Re: Minor Modifications to Approved Single Storey Rear Extension.

At: 94 Hunningley Lane, Stairfoot, Barnsley. S70 3DT.

For: Mr. & Mrs. S. Walker.

Approval No: 2009 / 0942. Approval Date: 14th September 2009.

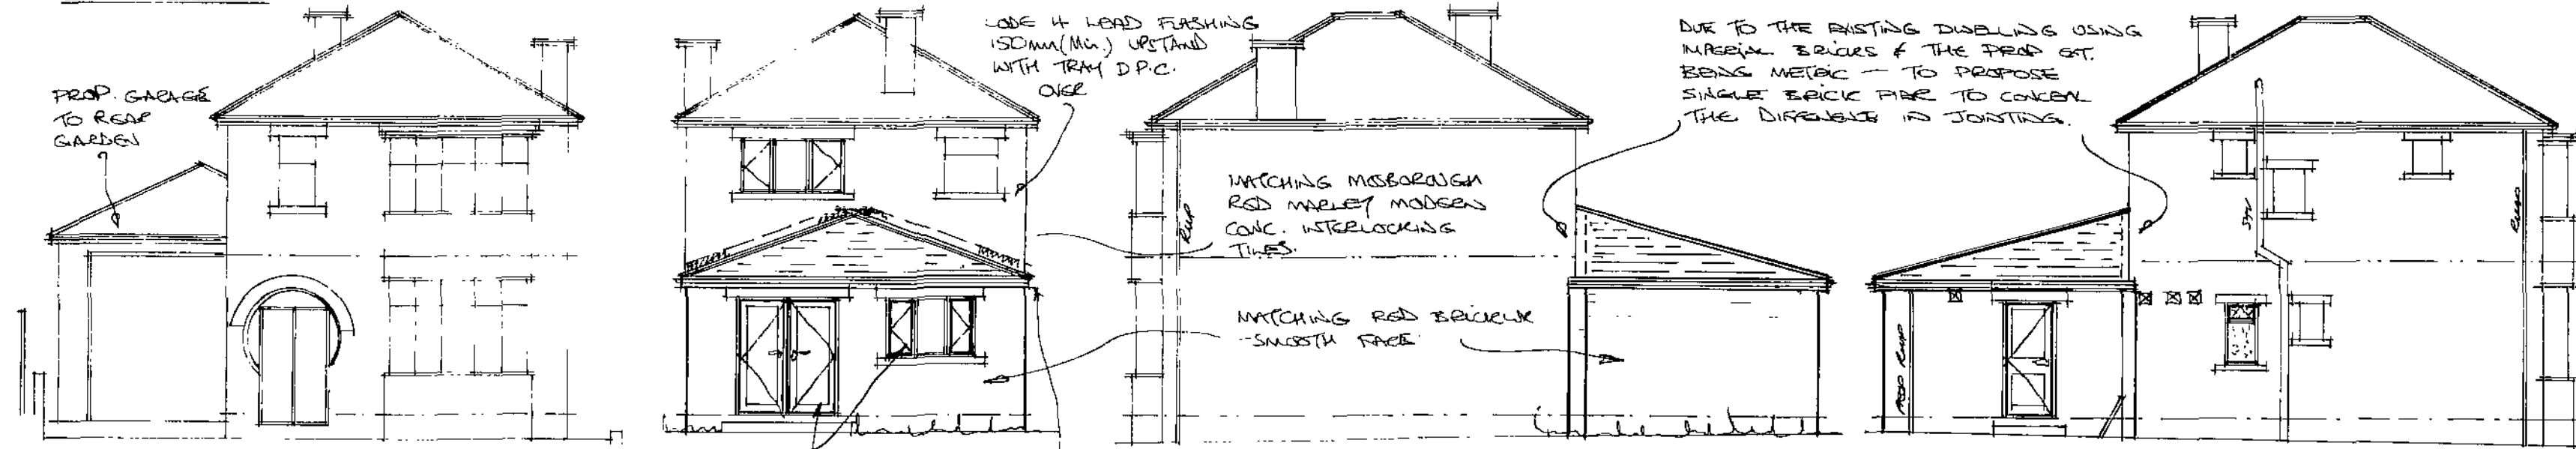
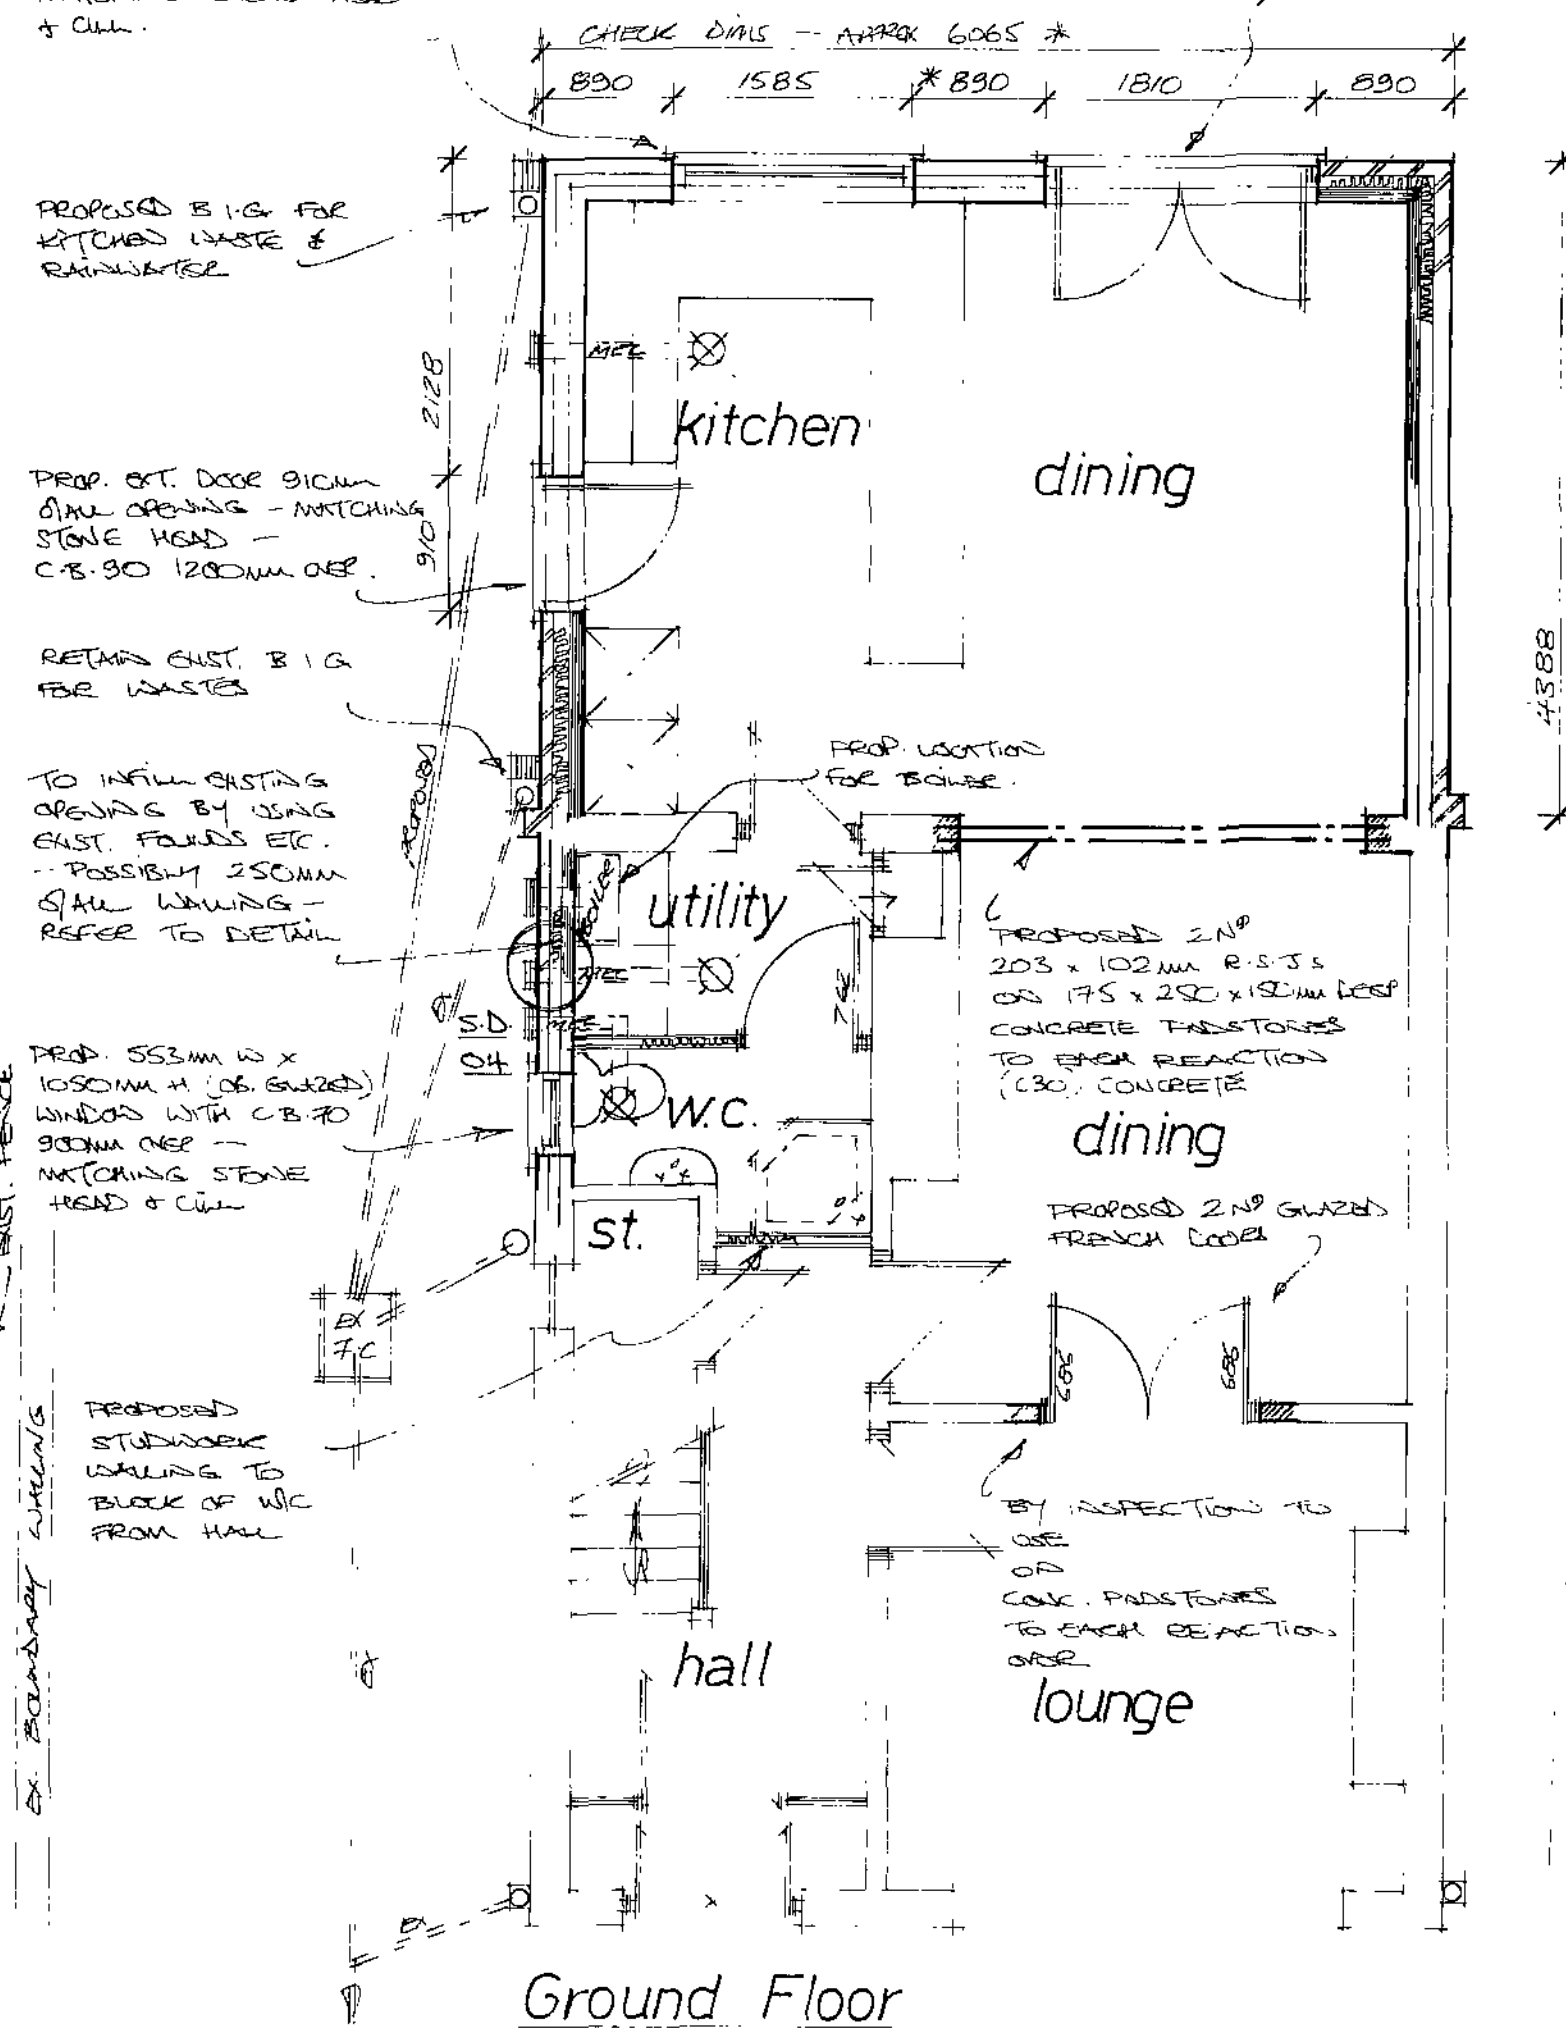
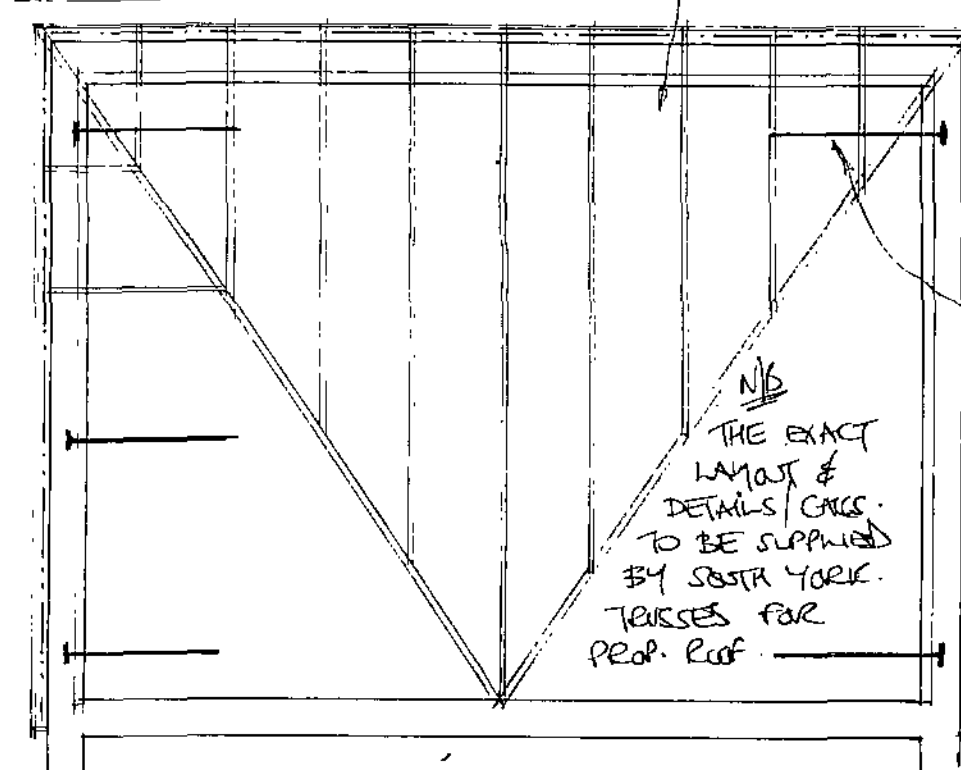
The alterations relate to the alteration of the roof construction from the approved "lean to" roof to the attached "hipped roof" as shown. As the existing dwelling and the approved detached garage are also both hipped constructions, we feel that this rear extension would also benefit from this type of construction. Take note the roofing materials will remain as approved.
